From: Tim Rainbird [REDACTED]
Sent: 07 September 2017 12:04
To: Simon Davis; Tom Woolner
Cc: Paul Cann
Subject: RE: BE/71/17/PL - Wickes, Bognor Drainage Scheme

Comments;

SW PACKAGE PUMP

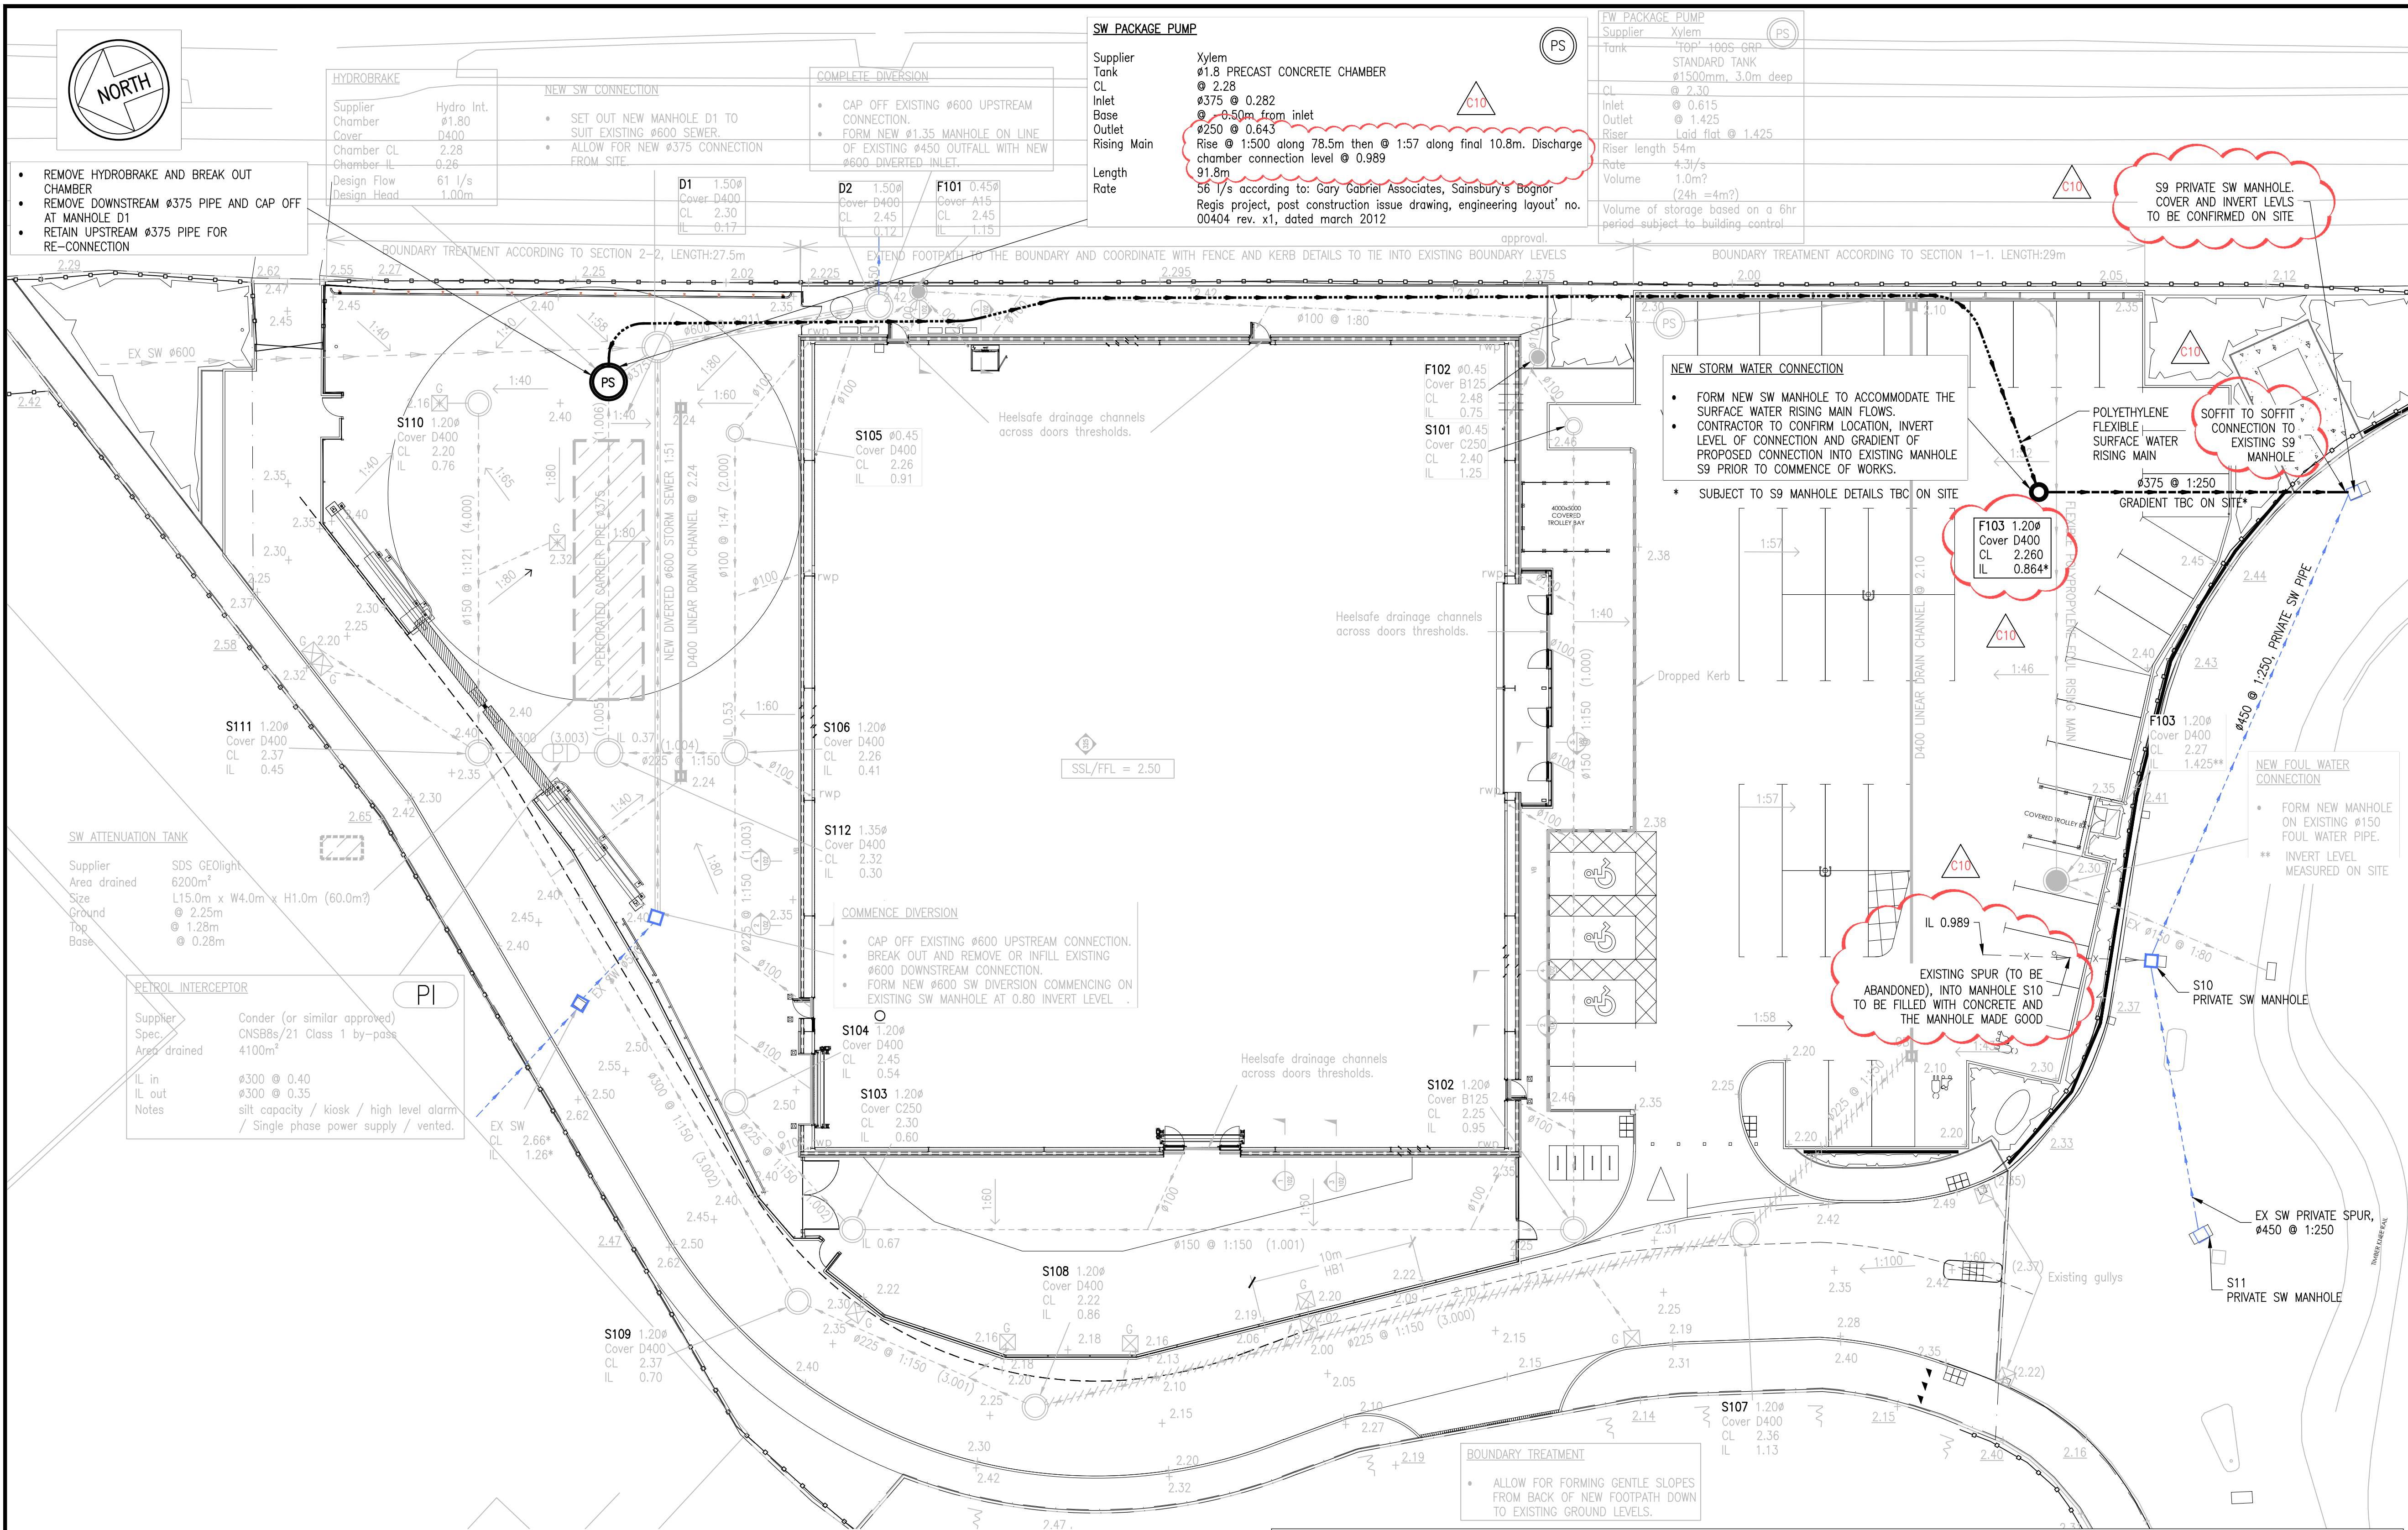
1. As the proposed connection is to manhole S9 on the Sainsbury's system, the proposed drainage layout plan needs to be amended accordingly, as the connection is currently shown to manhole S10.1. The rising main needs to discharge into a discharge chamber say min. 10m away from manhole S9, so that flows can dissipate as much as possible and reduce disruption to the main flow in the 450mm pipe. The gravity length of pipe between S9 and the discharge chamber should be laid at a minimal gradient but still achieve self-cleansing velocity. Please amend the drawings/construction details accordingly.
2. Please specify as to the arrangement in case of an alarm ie. are text messages automatically sent to nominated persons, etc/flashing beacon on station?
